Development: Demolition of Servac Int workshops; 1 No 2 bed annexe over parking bays with courtyard at front of annexe and two storey extension of current 2 storey rear structure keeping certain structures & features, to renovate them into a 2no. car port, with storage loft, re-landscaping to provide new gardens and biodiversity zones.

Location: Rock House Westergate Street Westergate PO20 3RJ

Thank you for the information you have sent following my previous letter. Unfortunately I am still unable to accept the application as valid until the following matters are resolved:-

West elevation - Roadside
1:50 @ A1

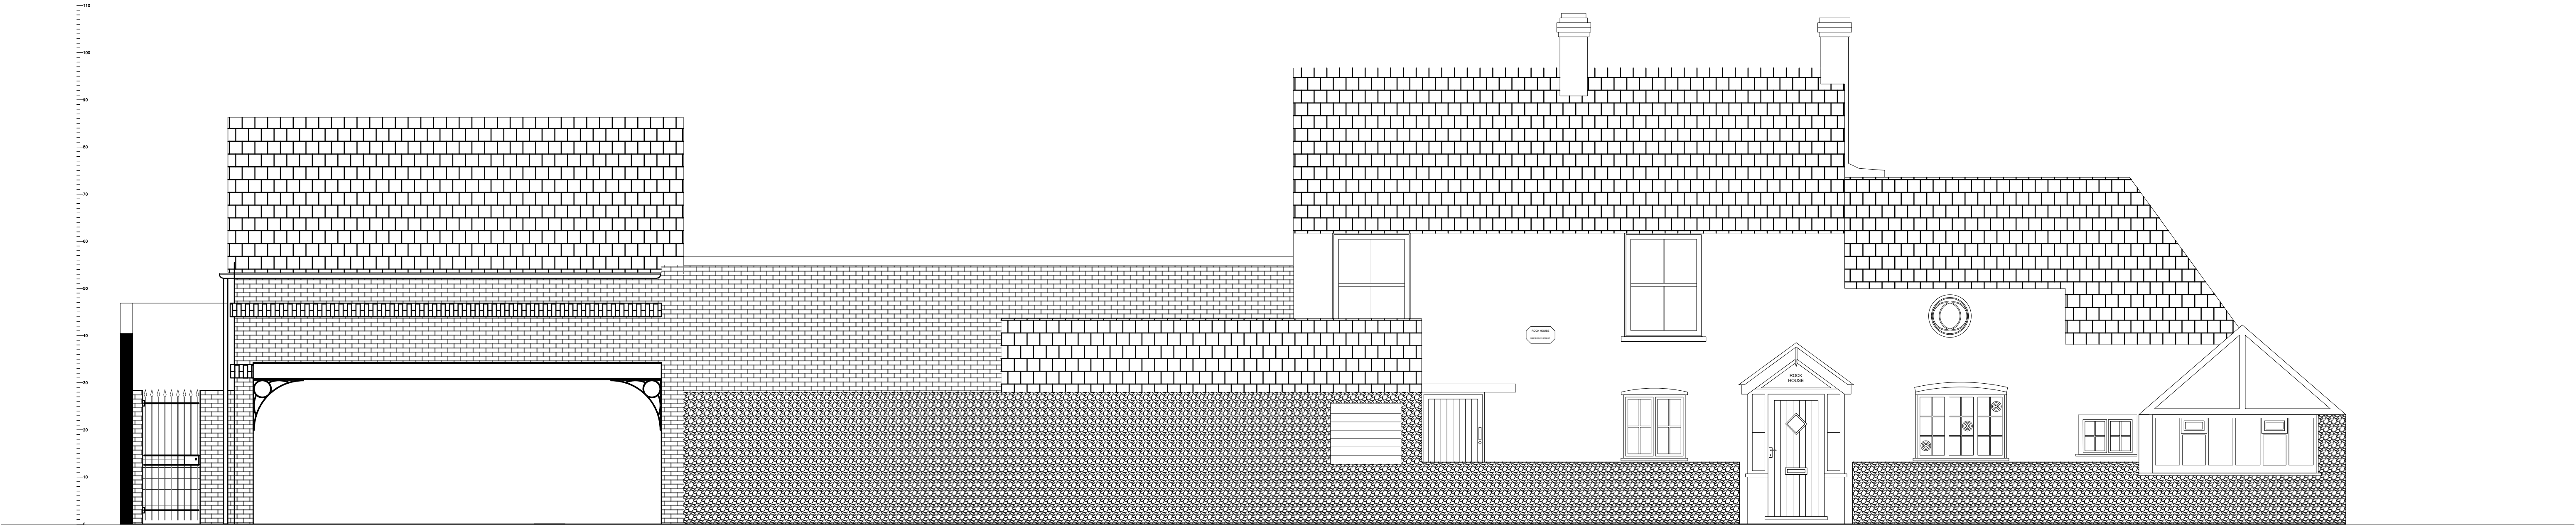
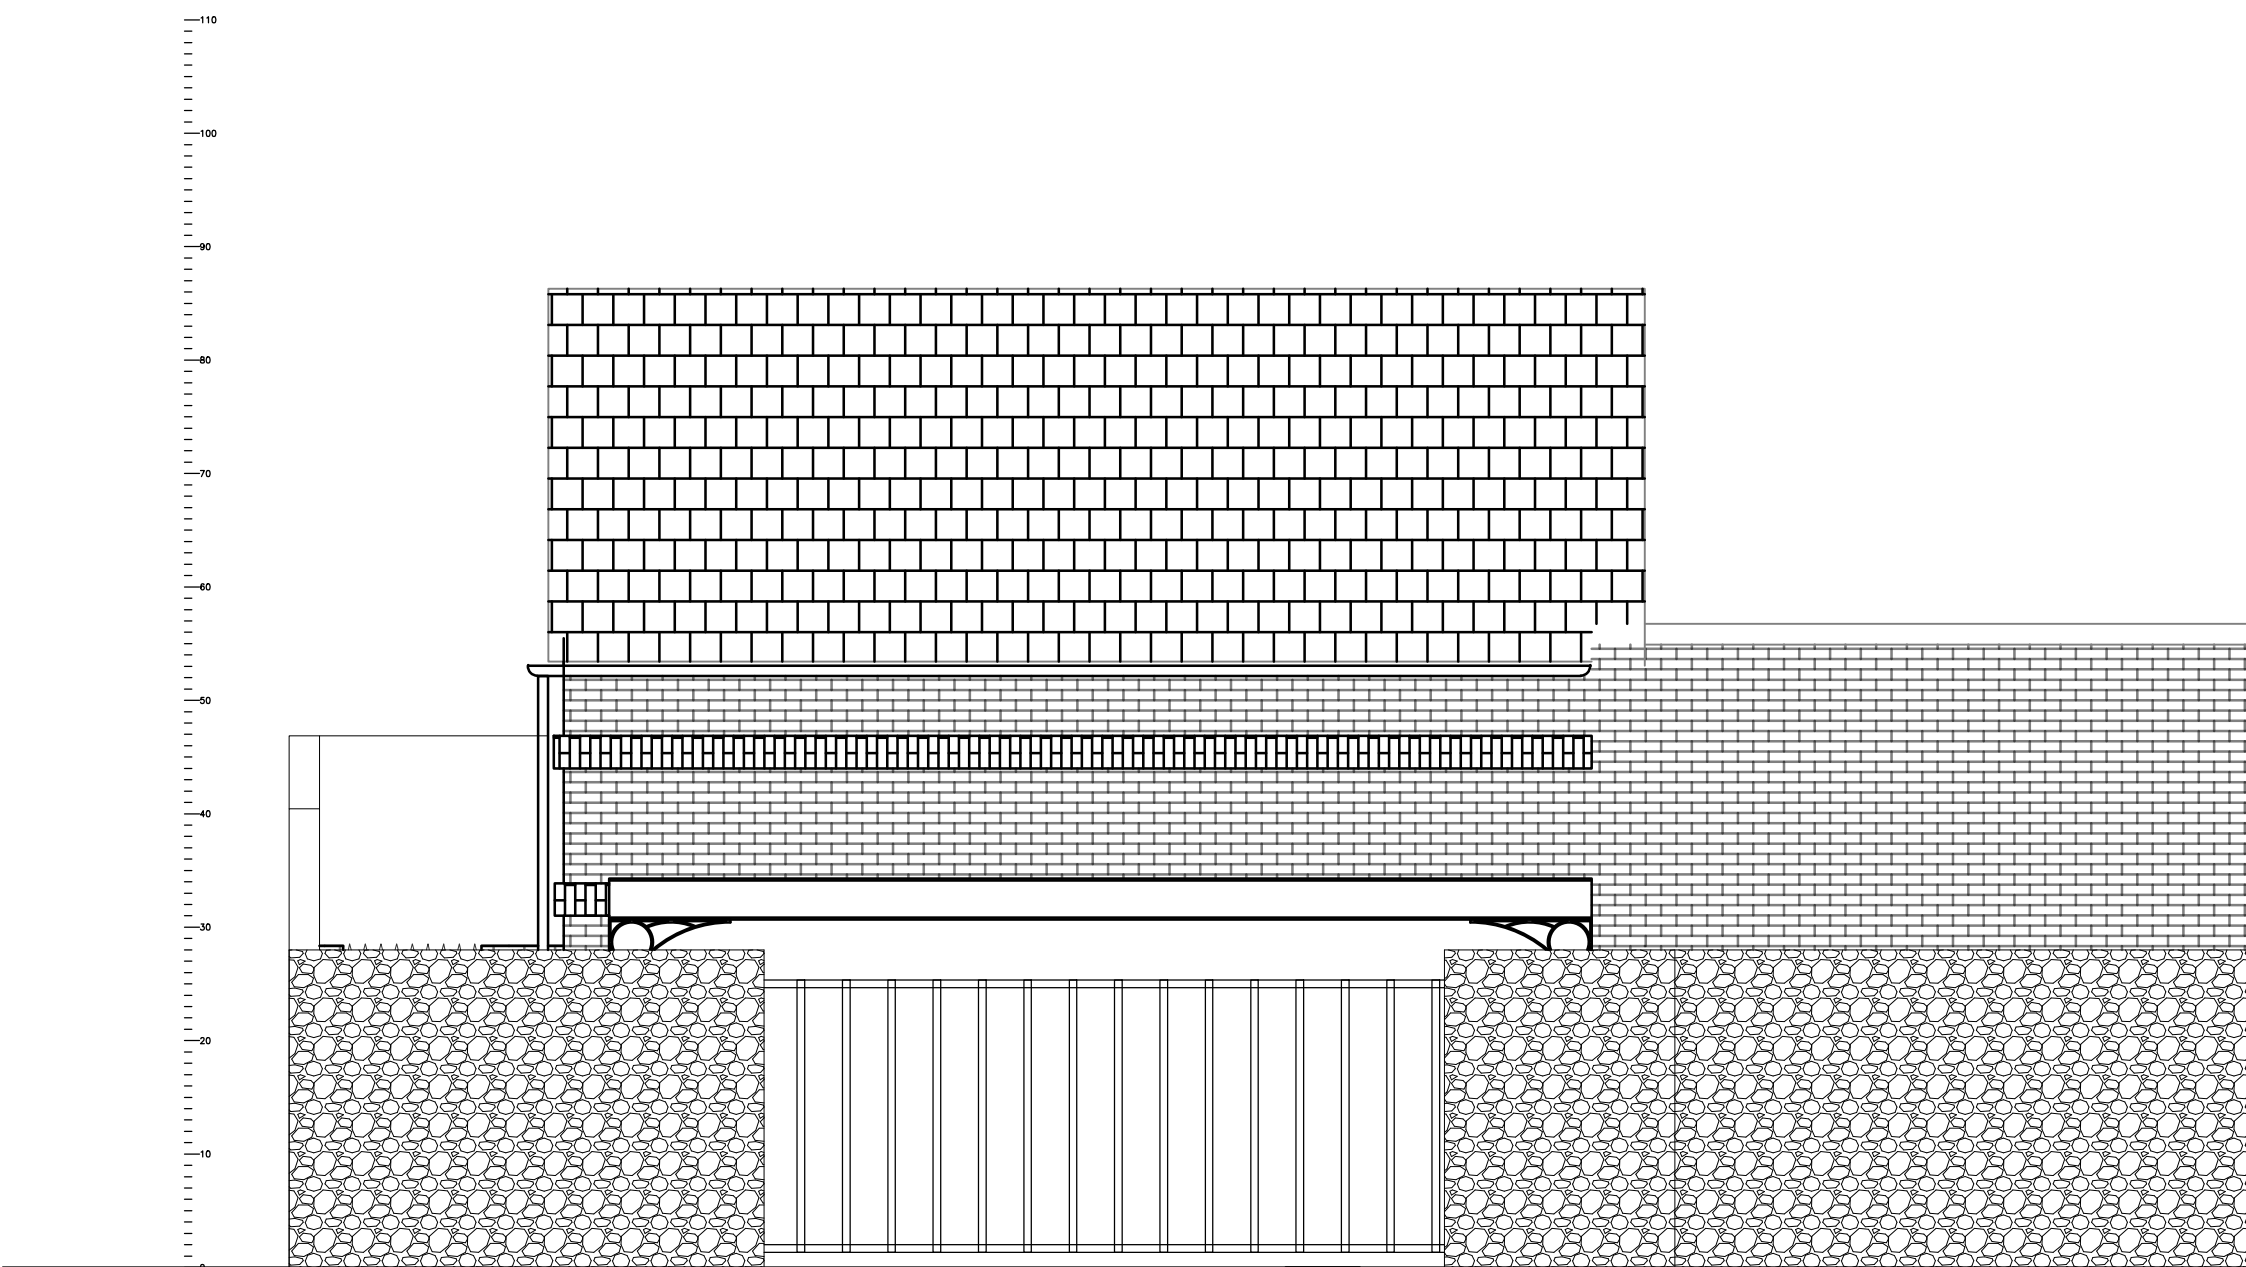
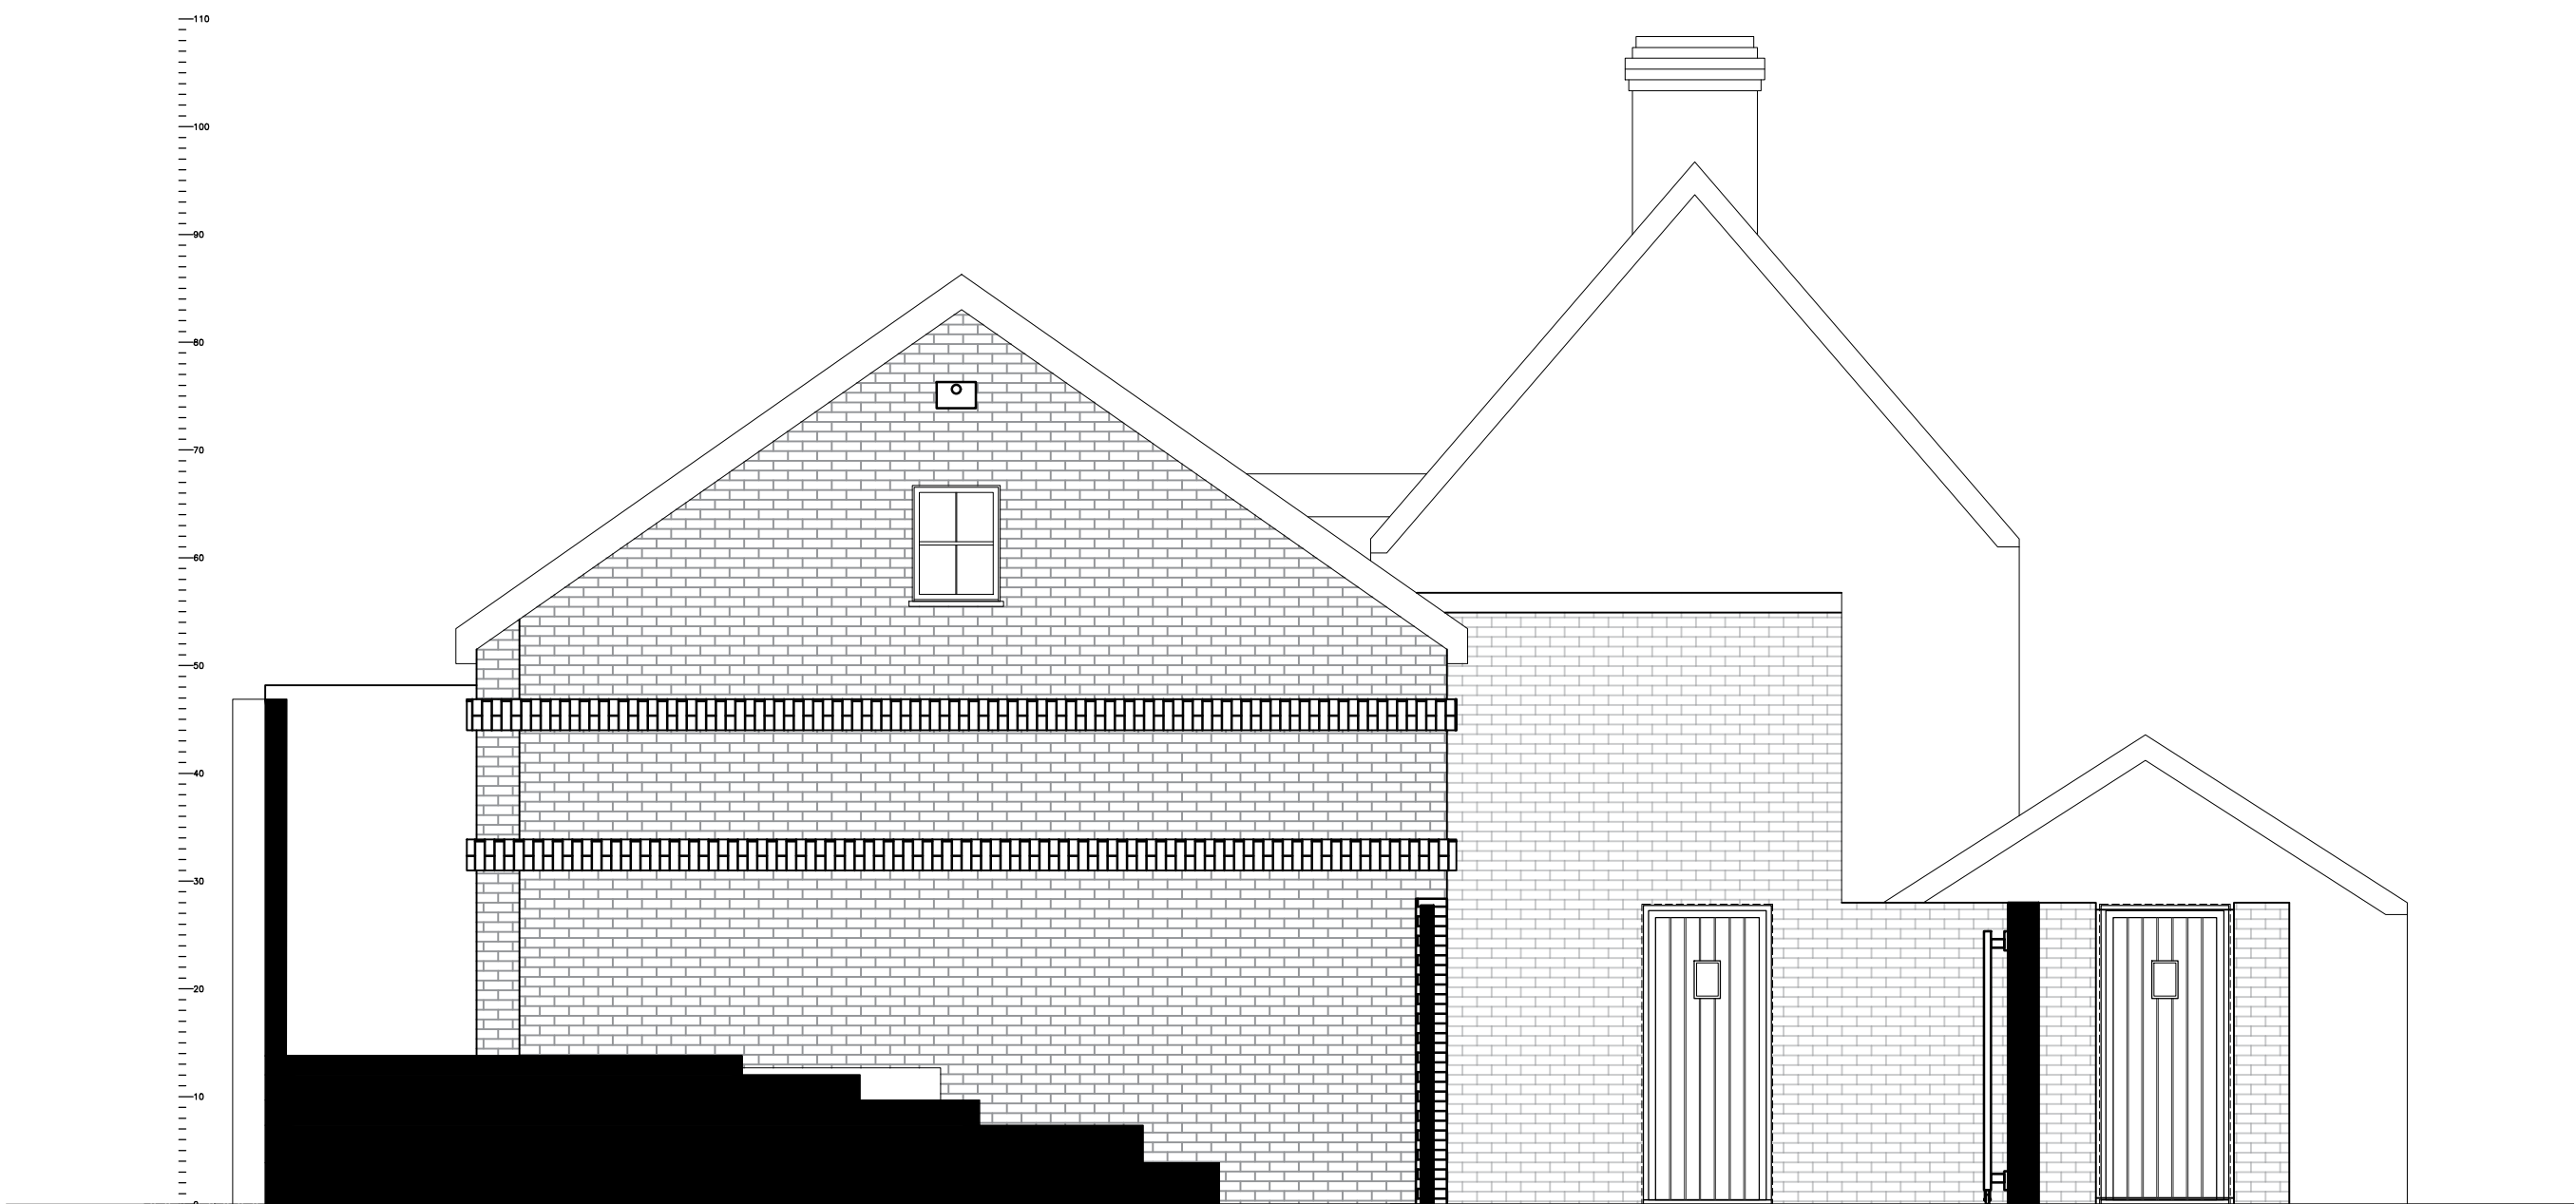
The ground floor plan and proposed north elevation do not accord at the office. Please amend accordingly.
